Planning Reference: **LU/221/25/DOC**

Site Address: **Land at Toddington Lane Toddington Lane Littlehampton BN17 7PN**

Planning Description: **Approval of details reserved by condition imposed under LU/246/24/PL relating to conditions 8-surface water drainage and 9-maintenance and management of surface water drainage.**

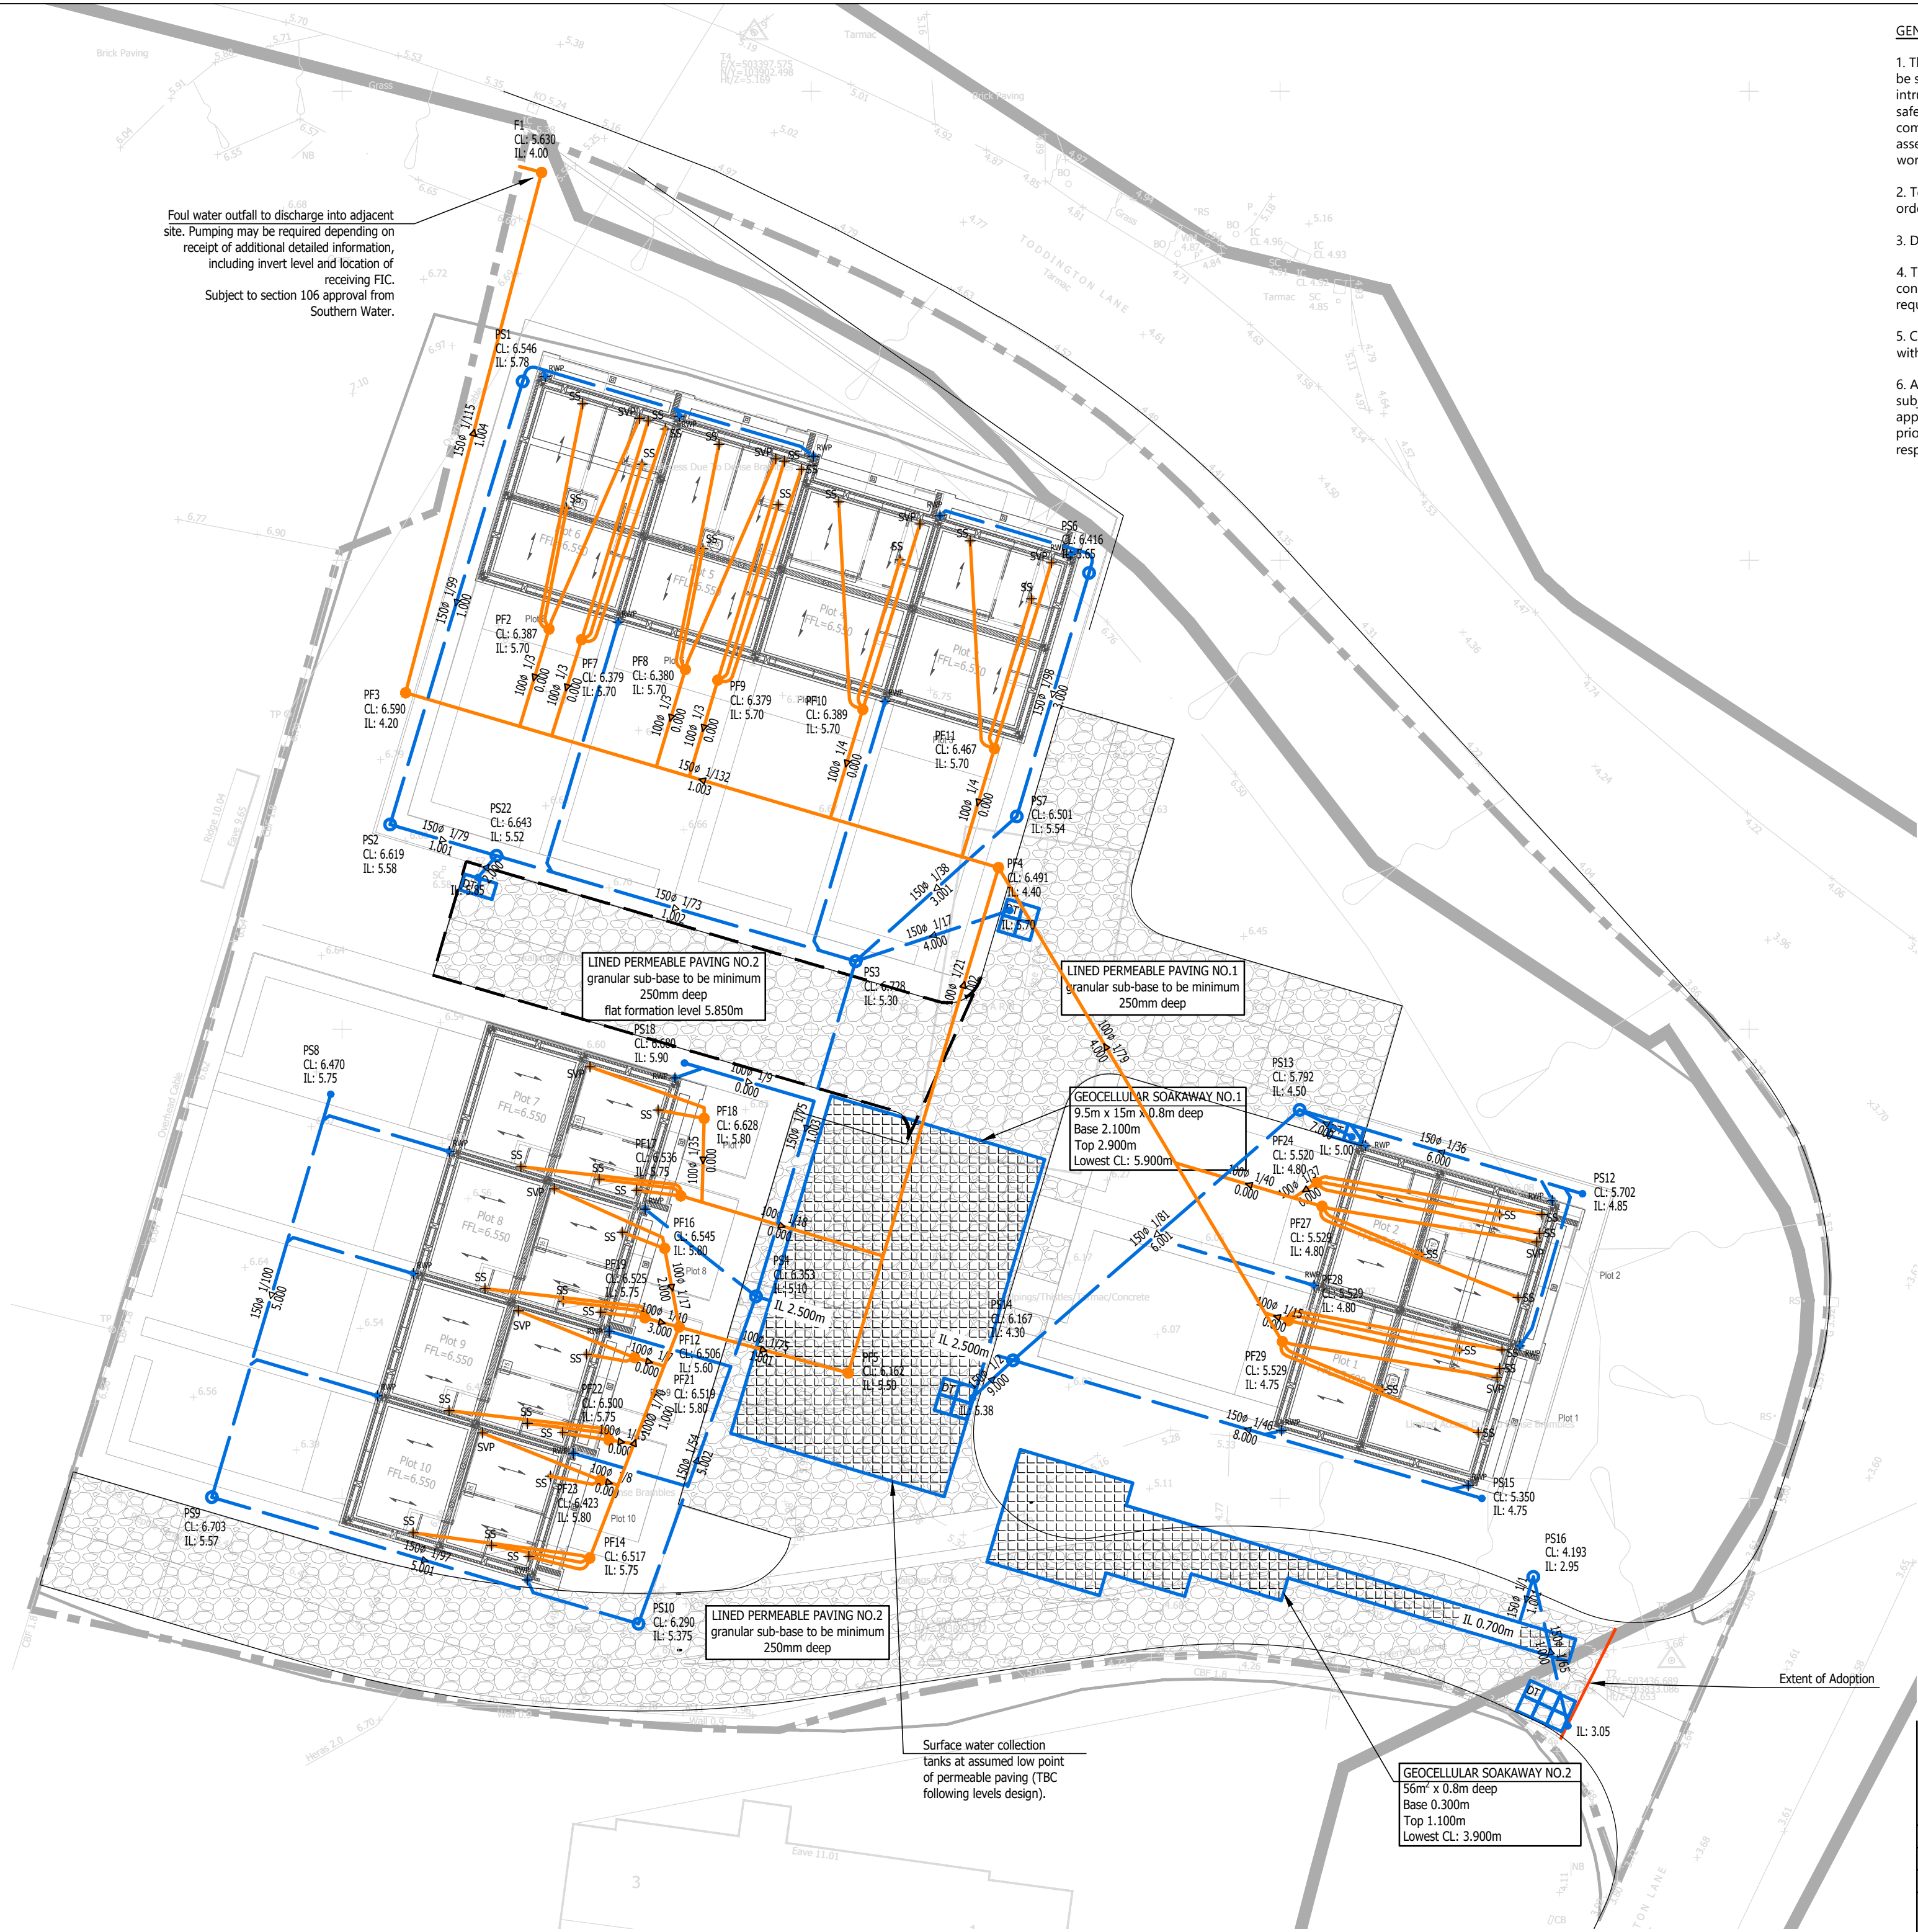
The LLFA notes that significant changes have been made to the approved surface water drainage strategy with infiltration now being utilised despite being ruled out during previous testing. We understand that two soakaways are proposed and will be set within the chalk layer that showed viable infiltration rates through new testing. In principle, this new drainage strategy is acceptable, however we require further information at this stage. The condition requires detailed drainage plans and while a layout plan has been provided we would ask that cross-sections and long-sections of the proposed drainage features (permeable paving, soakaways, manholes etc.) are submitted for review. These details should include sizes and depths to match the drainage layout plan and the hydraulic calculations.
